Proposed development at "10" Second Avenue - Planning ref FP/32/21/PL

Our residence is immediately behind the developers' property ("Seafurl" - No 10 Second Avenue). Whilst the proposed plot designated for the new house number forms part of the land of Seafurl-No10 Second Avenue, Arun DC Planning Dept will be aware that 'Seafurl' was extended to the south in about 1984 by the previous owner (the late Mr. E Lacey), with a single-story extension. At that time, we were told by Mr Lacey that his extension would prevent further development on the adjoining area of the garden.

PROPOSED ELEVATIONS

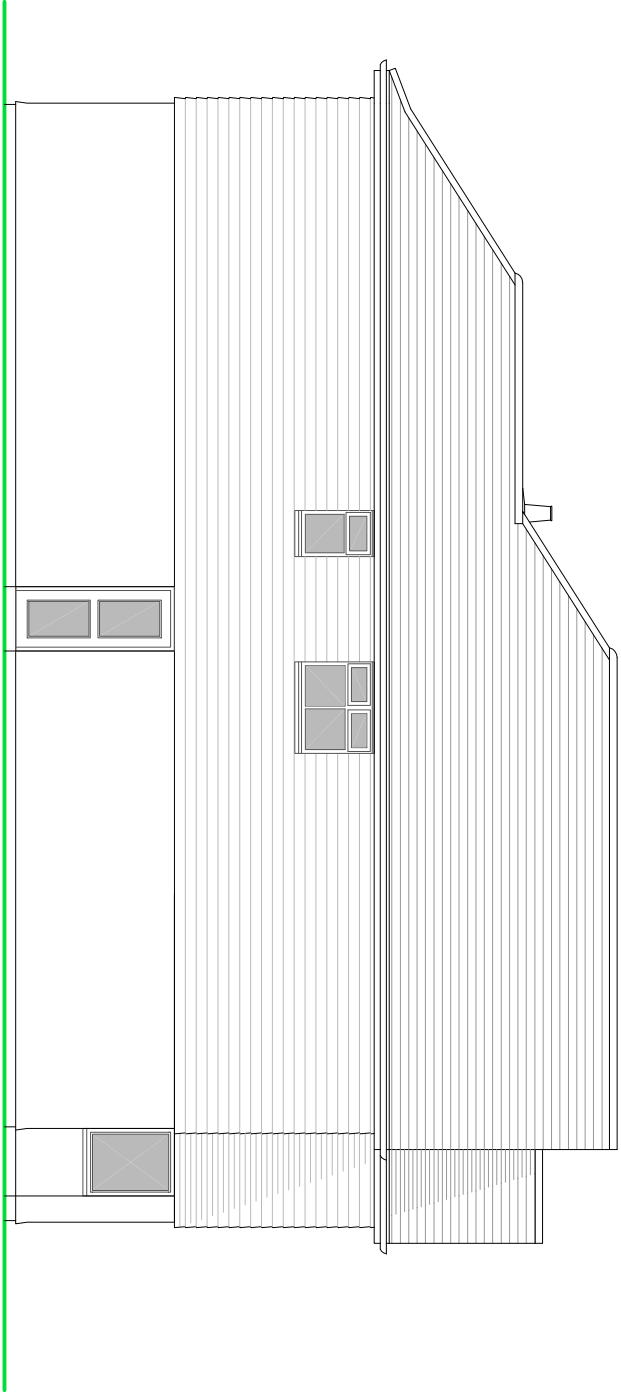
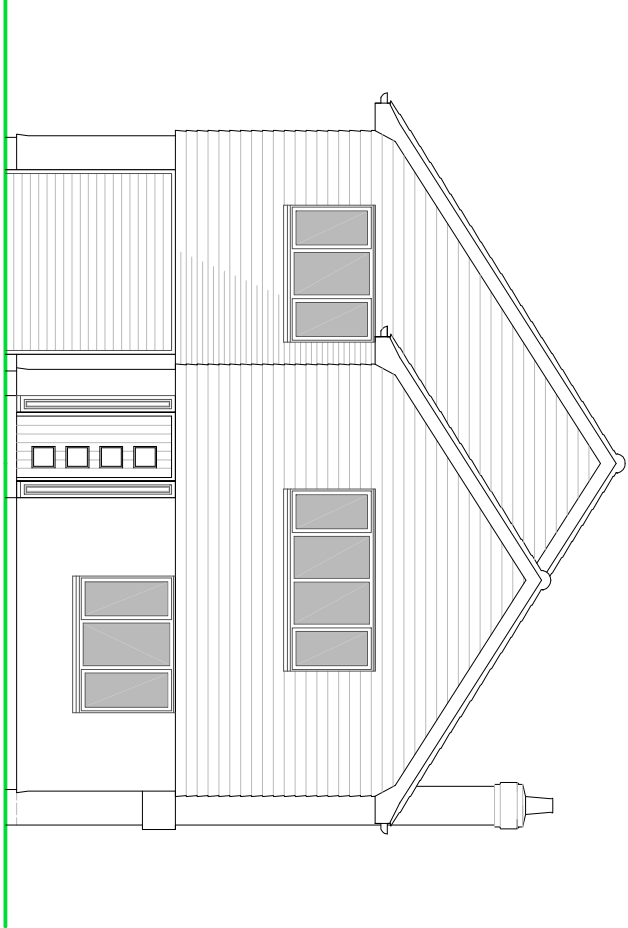
Architecturally, the elevations replicate the adjoining houses Nos 8 & 9, that were built in the 1960's. Every other house in that road has a distinctive design. (which is a requirement dating back to the sale of plots in the 1930's).

In our opinion another New England style is unimaginative, and more effort should be made to achieve a distinctive and unique roadside elevation, in keeping with road and the immediate neighbourhood. A good example of what could be achieved on the front elevation is demonstrated by the development of Jacken Close, where houses are similar but finished details brings distinct differences.
